Application for a non-material amendment following a grant of planning permission.

DEMOLITION OF ATTACHED PREFABRICATED GARAGE & UTILITY AREA.  
REPLACEMENT WITH SINGLE STOREY EXTENSION TO PROVIDE ELDERLY  
RELATIVE ANNEX TO THE WEST ELEVATION, AND A GLAZED  
CONSERVATORY TO THE EAST ELEVATION

FG / 123 / 08

| DWG. No.  | 191.10.04                                                | Scale:     | 1:50 & 1:100 |

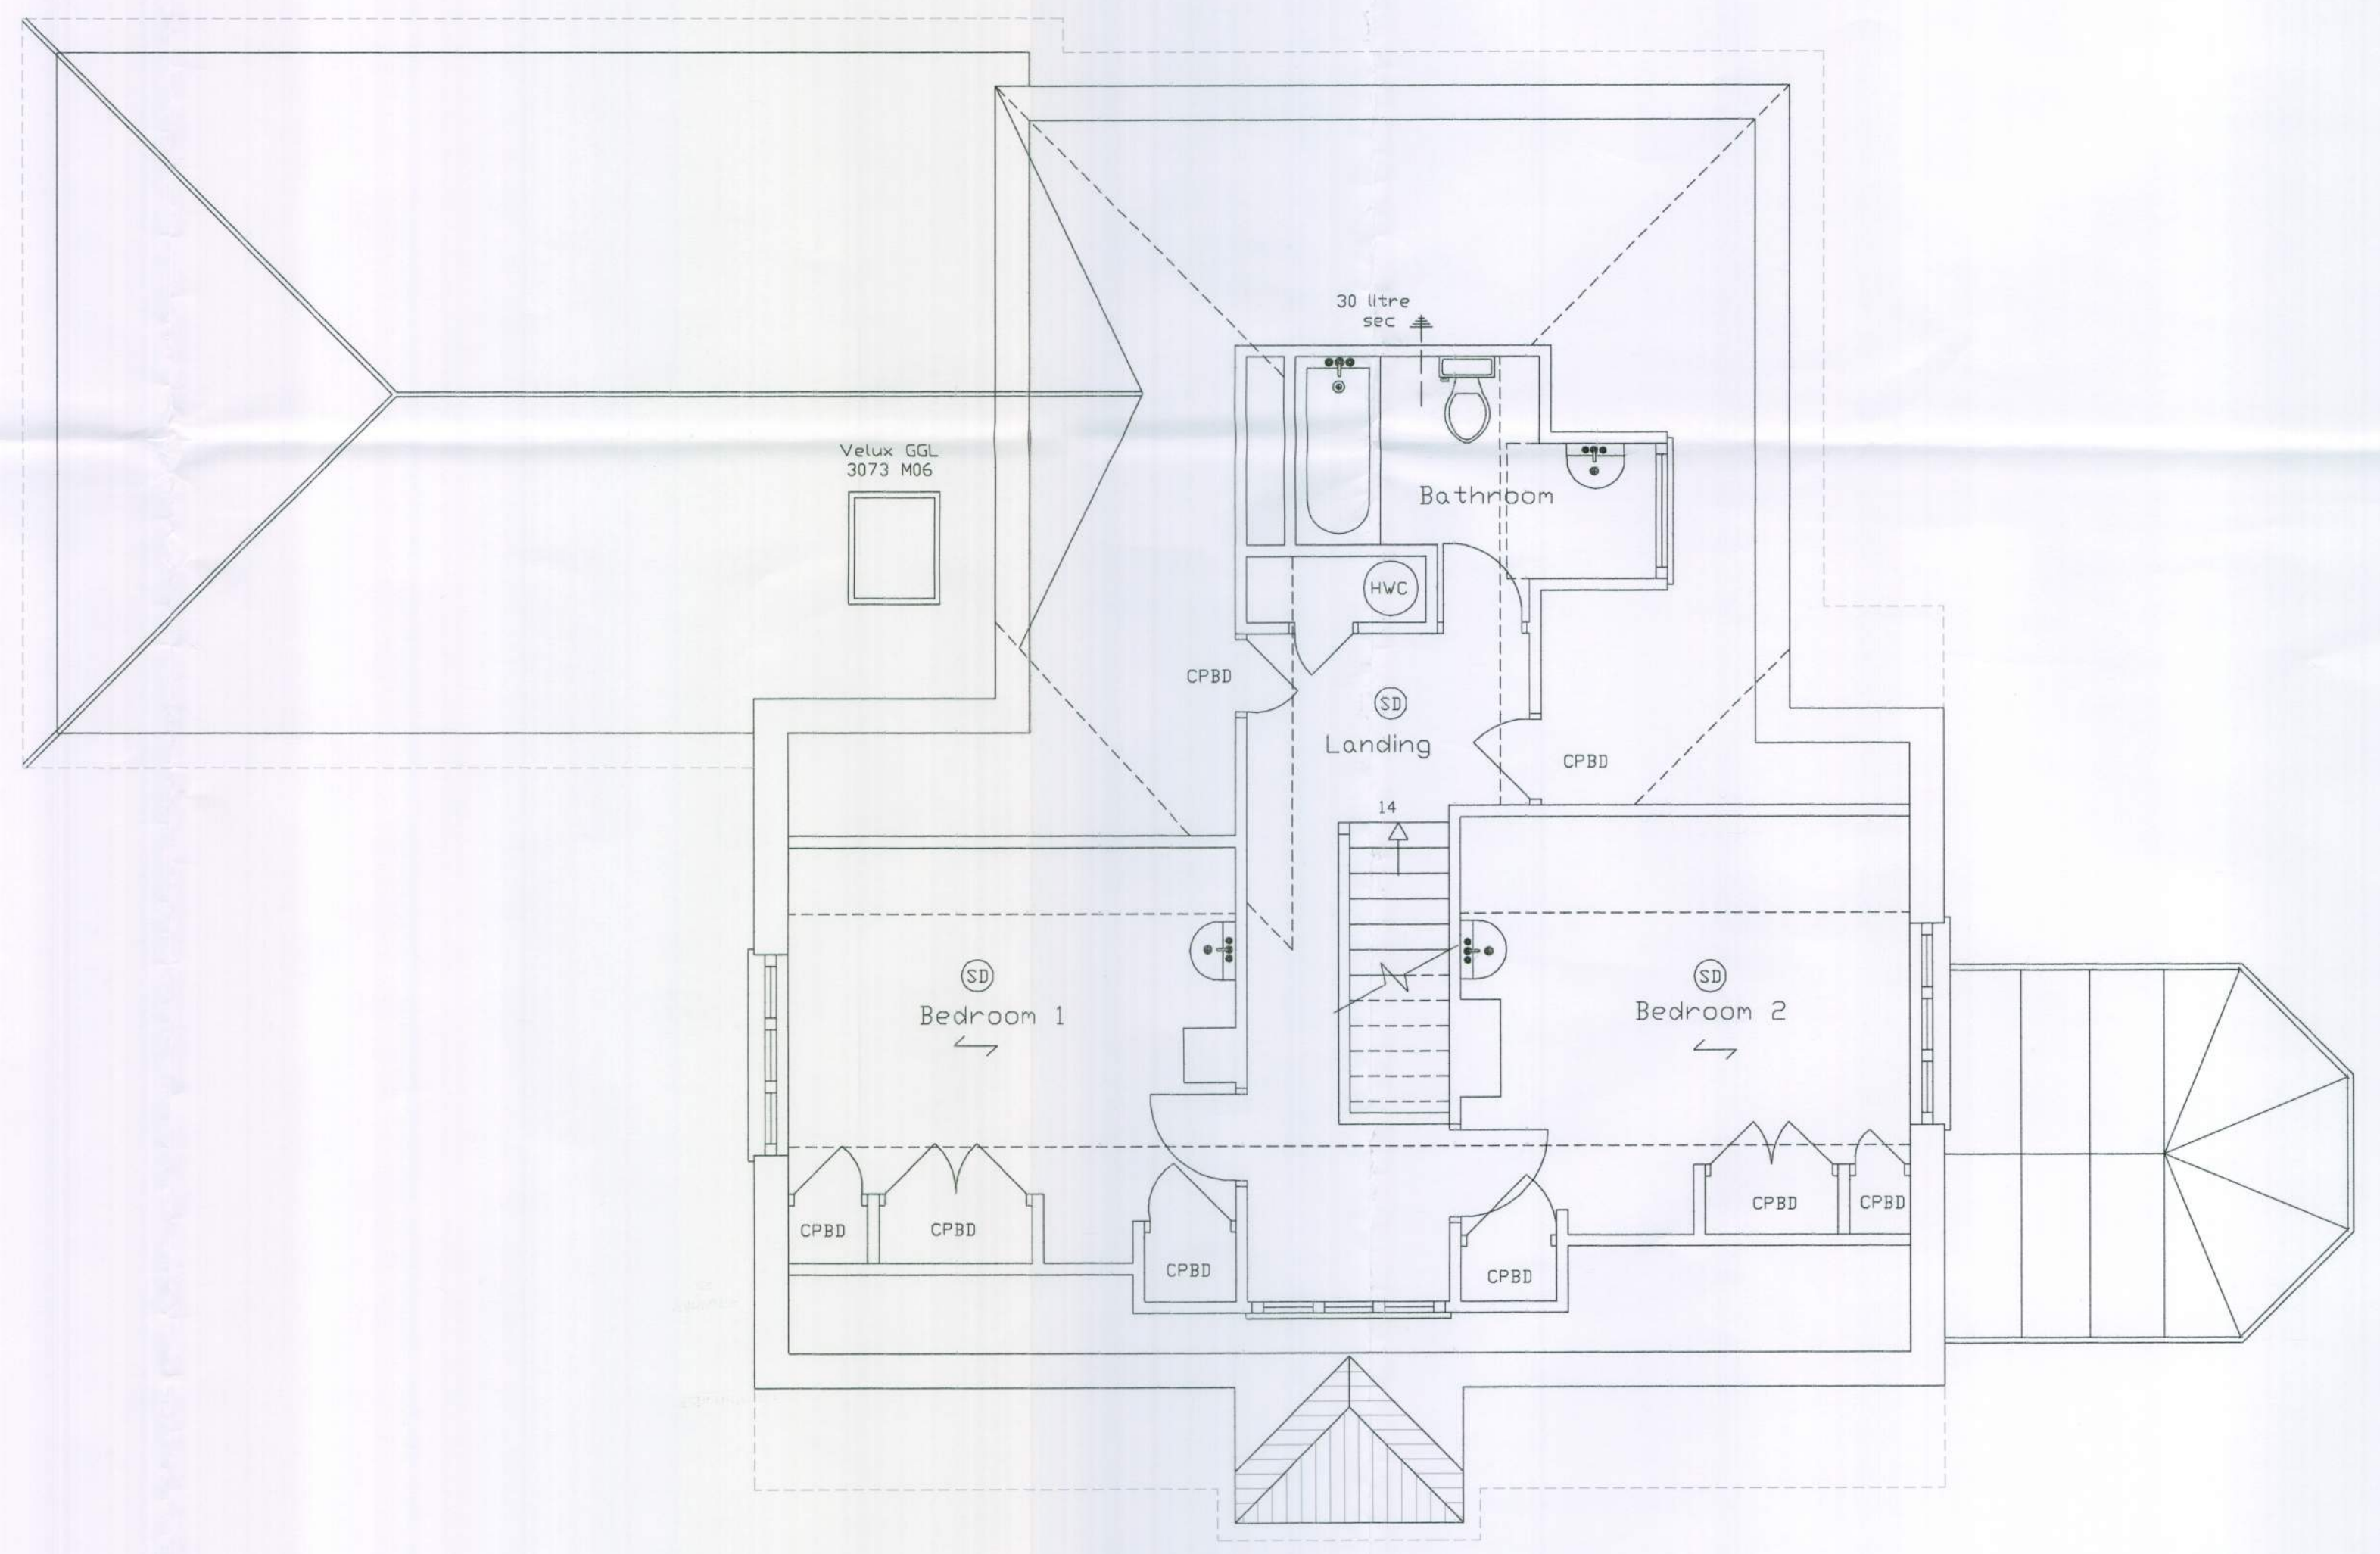
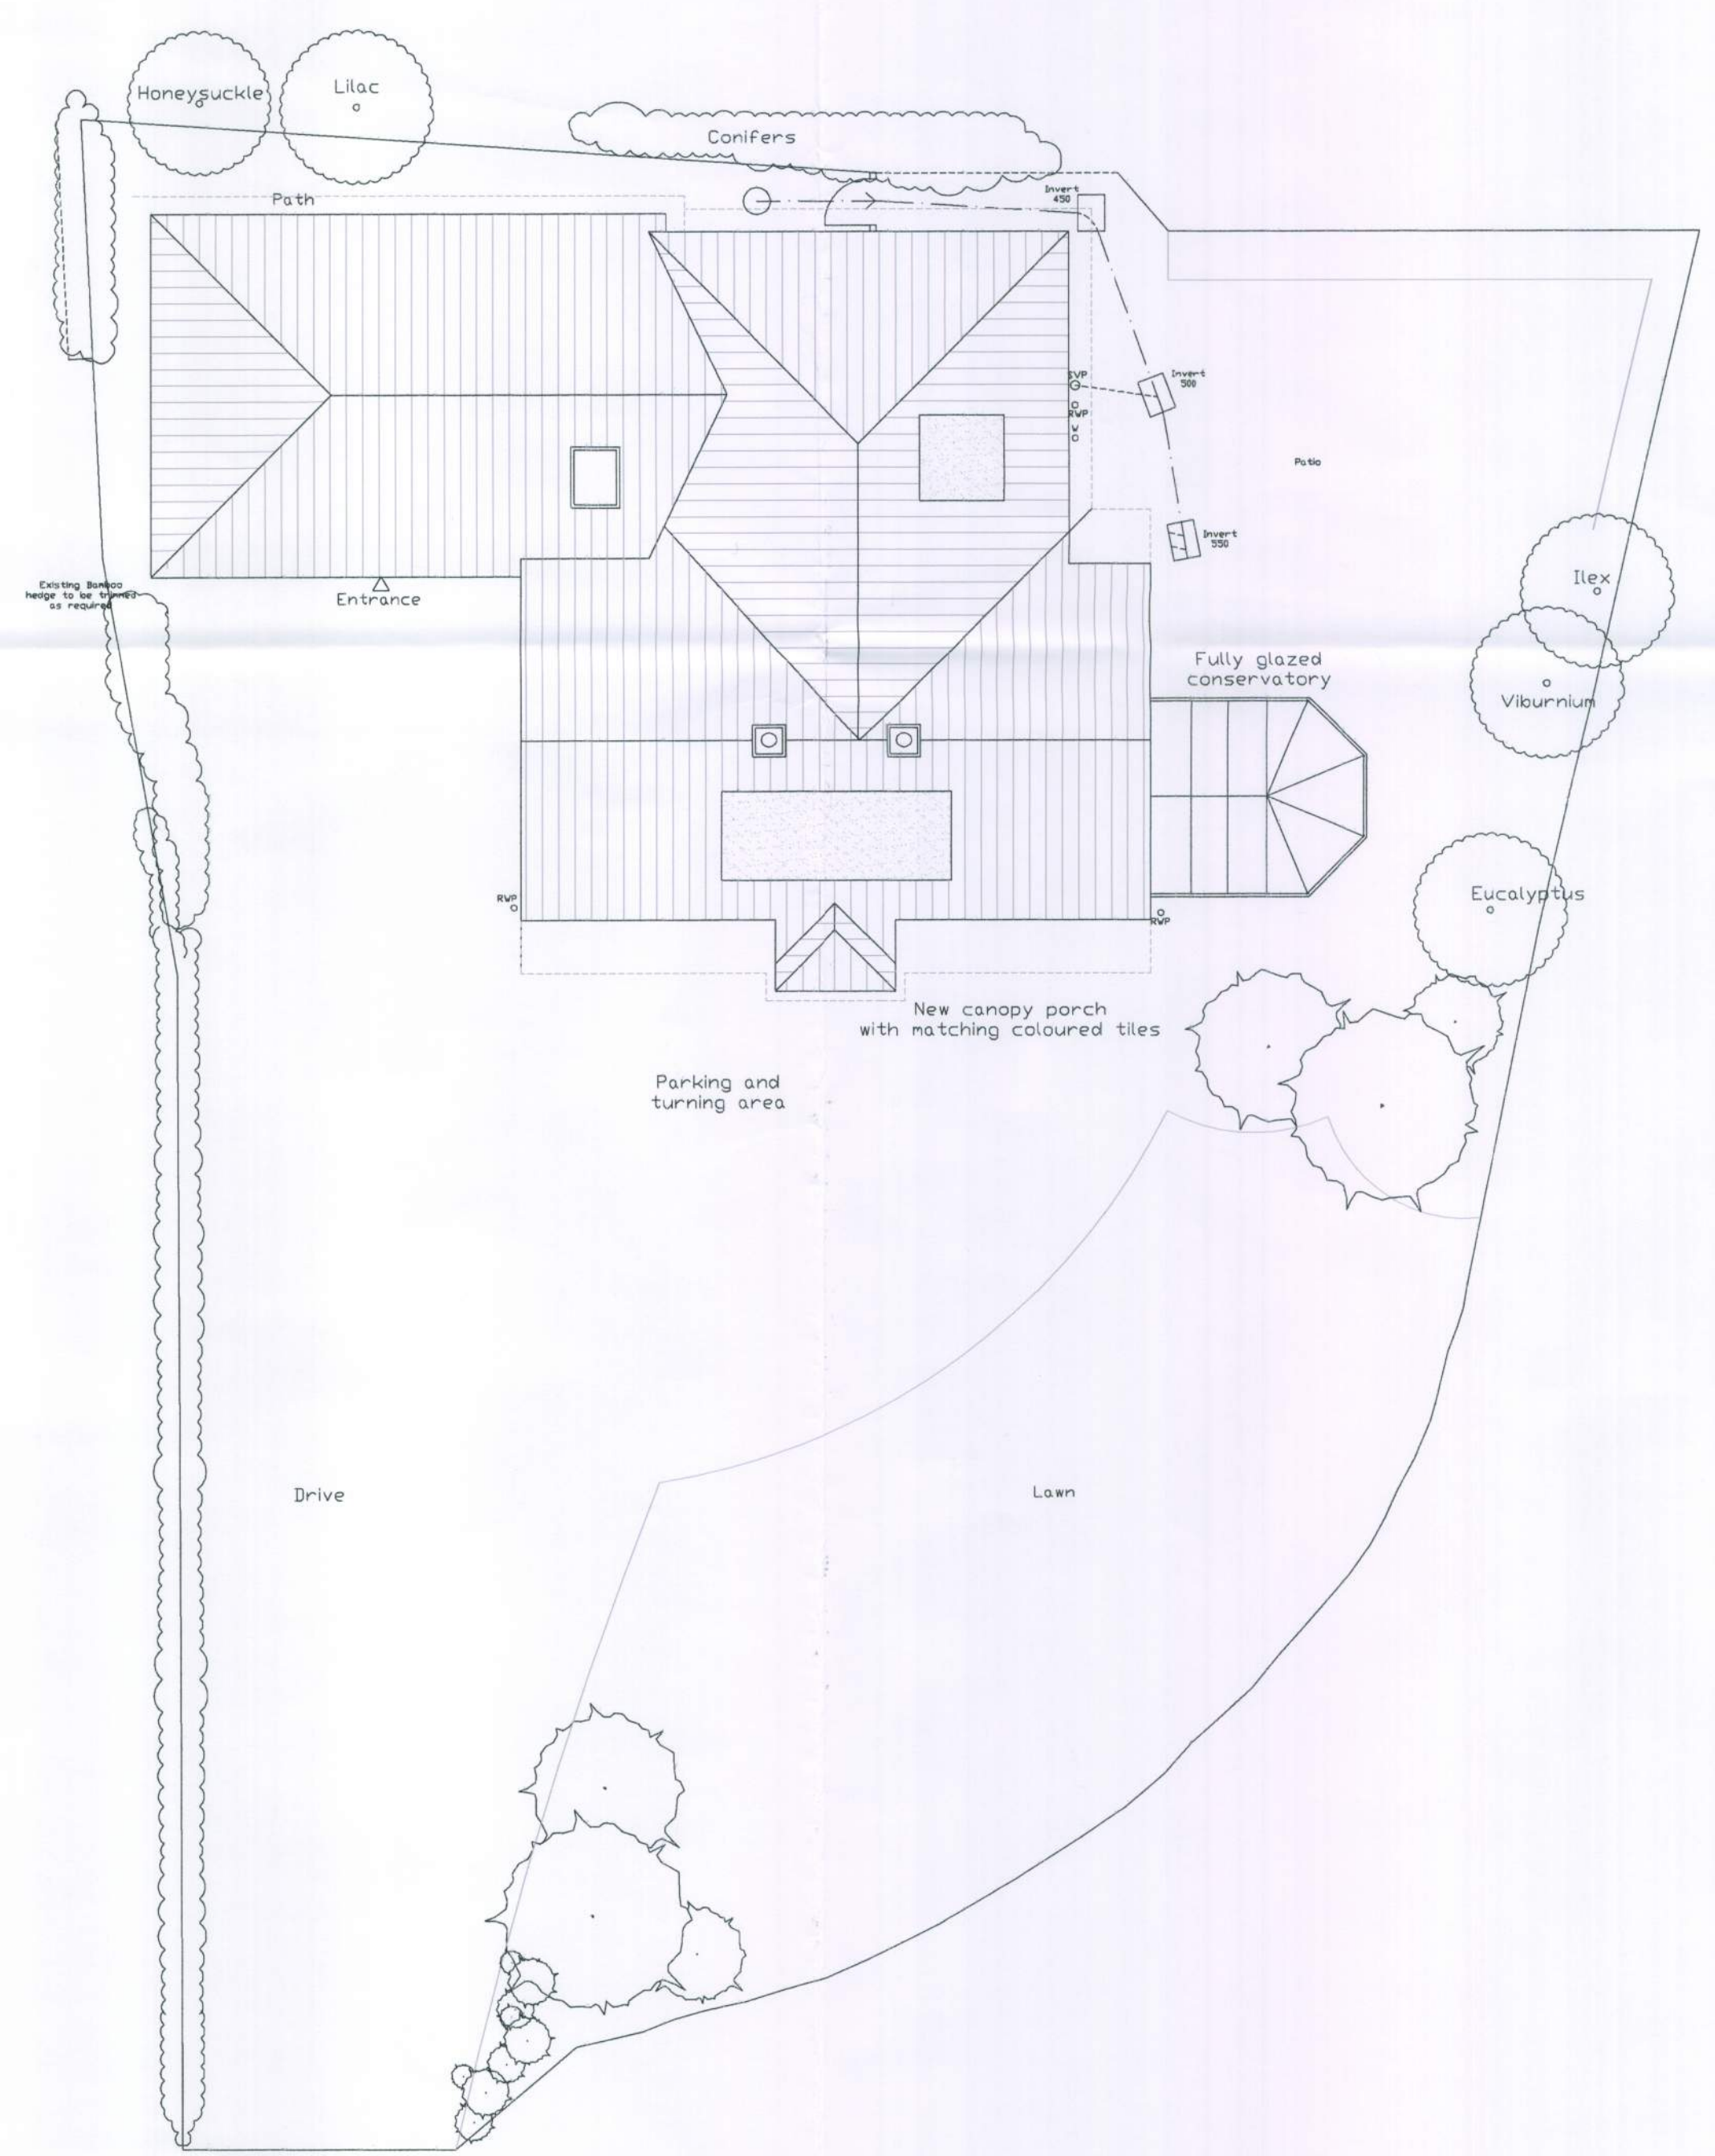
- REDUCTION IN SIZE OF THE APPROVED DRAWINGS TO EXCLUDE THE FRONT GARAGE & STORE AREA, BUT TO INCLUDE ALTERATIONS TO THE INTERNAL LAYOUT WITH SUBSEQUENT AMENDMENTS TO WINDOWS & DOORS.
- REDUCTION IN SIZE OF CONSERVATORY FROM 12.5 SQM TO 10 SQM, WITH REDUCTION IN HEIGHT AND AMENDMENT TO DESIGN.

191.10.01 191.10.02 191.10.03 191.10.04
